## Fire Marshal Division

**Re: Krigen Pharmaceuticals  
800 Edwards Brothers Dr.  
Lillington, NC 27546**

**Application Number FMFW1912-0002**

1 REVISED OFFICE LIGHTING PLAN
 SCALE: 3/16" = 1'-0"

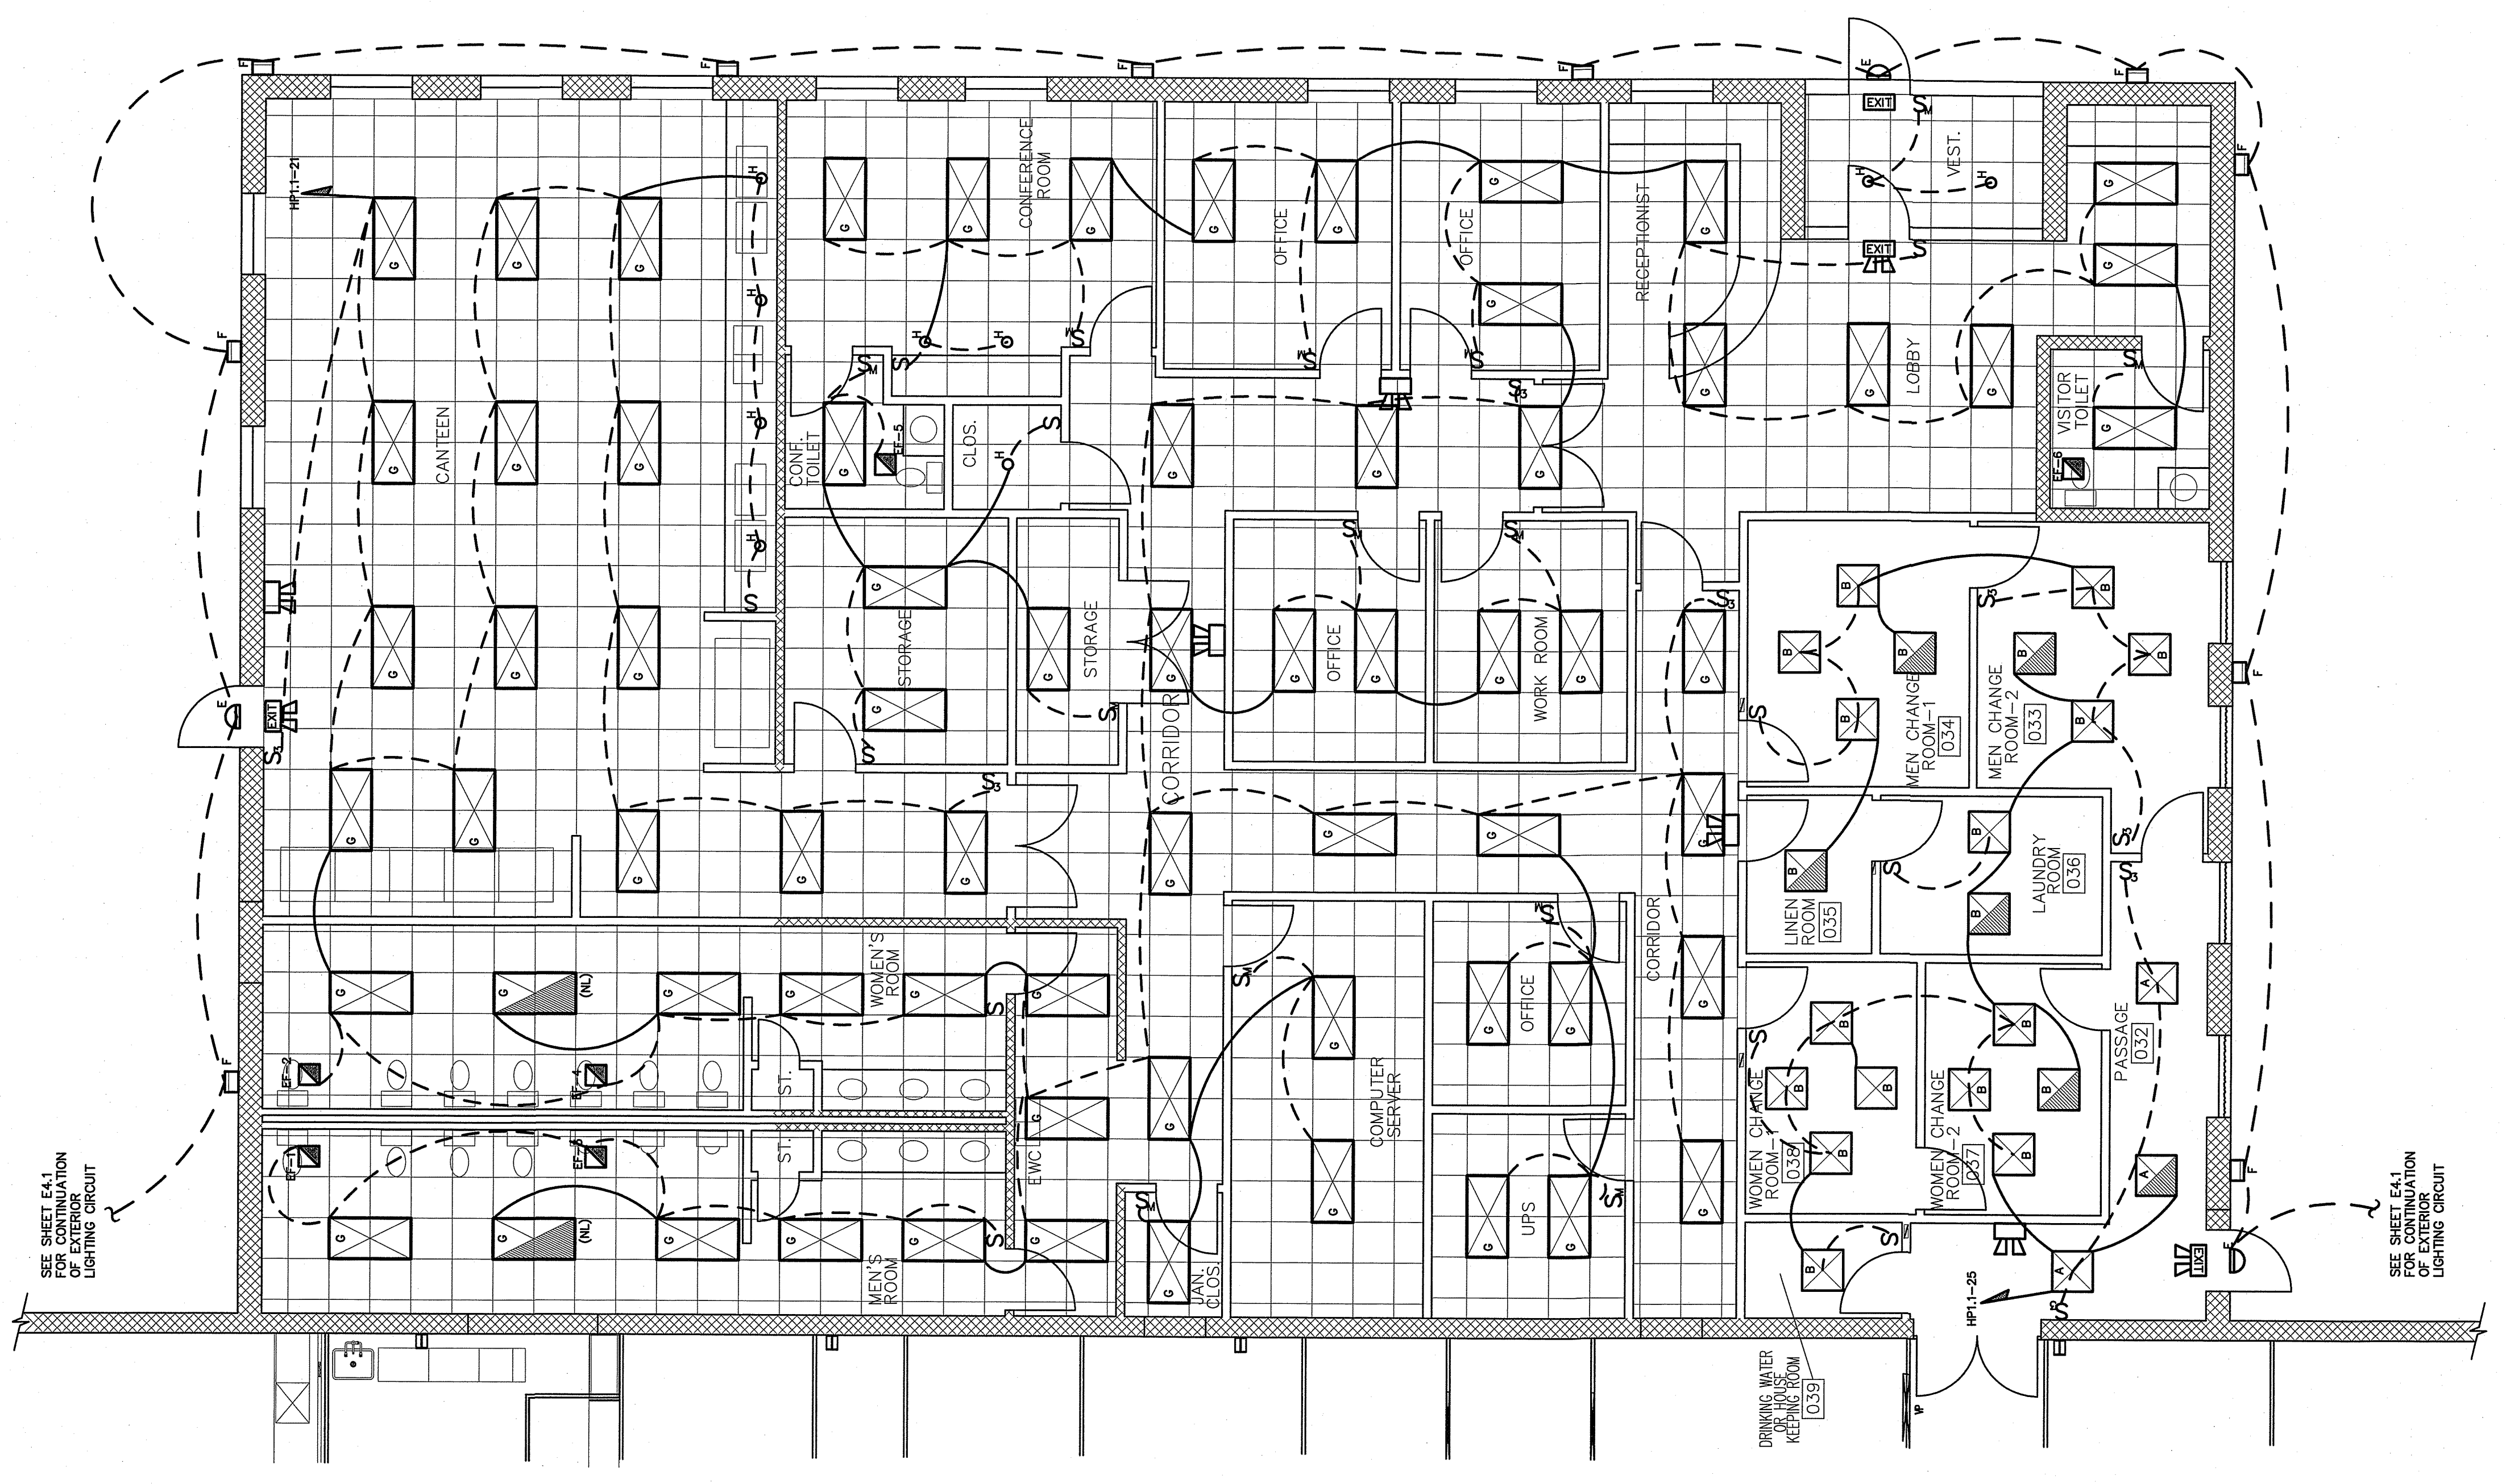
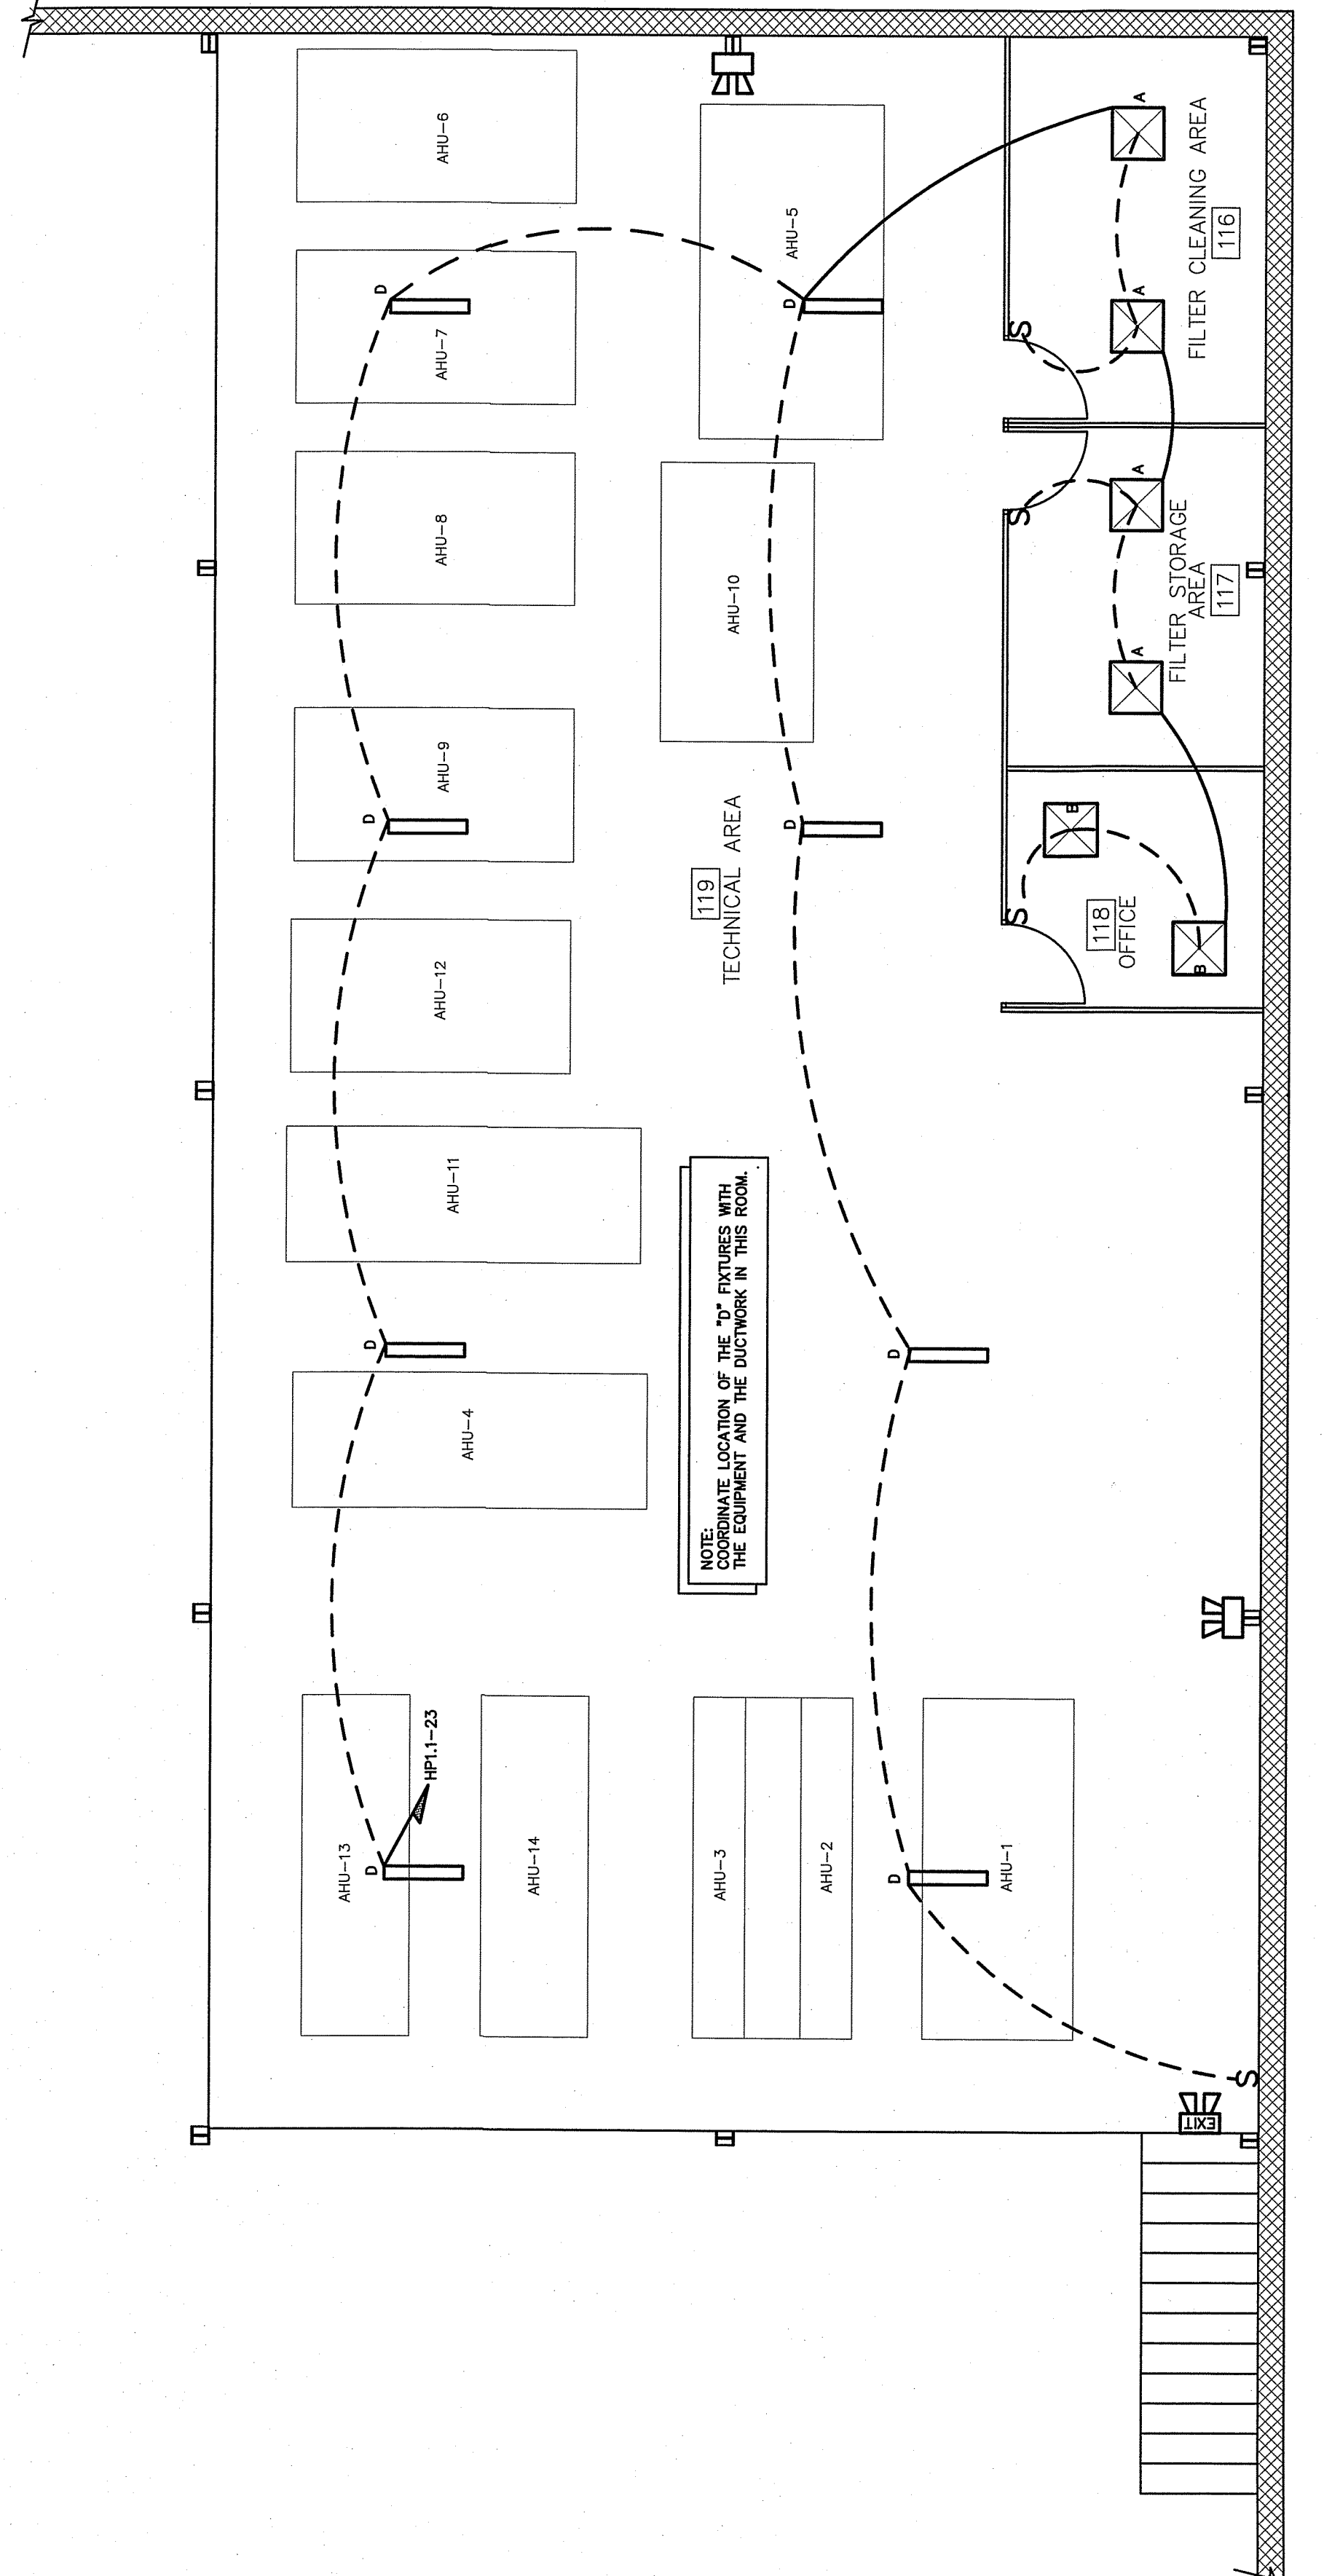
- Notes
  - A final fire inspection is required.
  - Please submit an occupancy load for the building as none is shown on the plans that were submitted.
  - Please clarify what exits will be utilized to egress occupant loads from spaces. One sheet shows multiple exits, while the electrical plan only shows select exits marked as emergency exits.
  - Please ensure all exits in the paths to an emergency exit is swinging in the direction of egress.
  - Schedule all fire inspections through the Fire Marshal's Office. (910) 893-0742
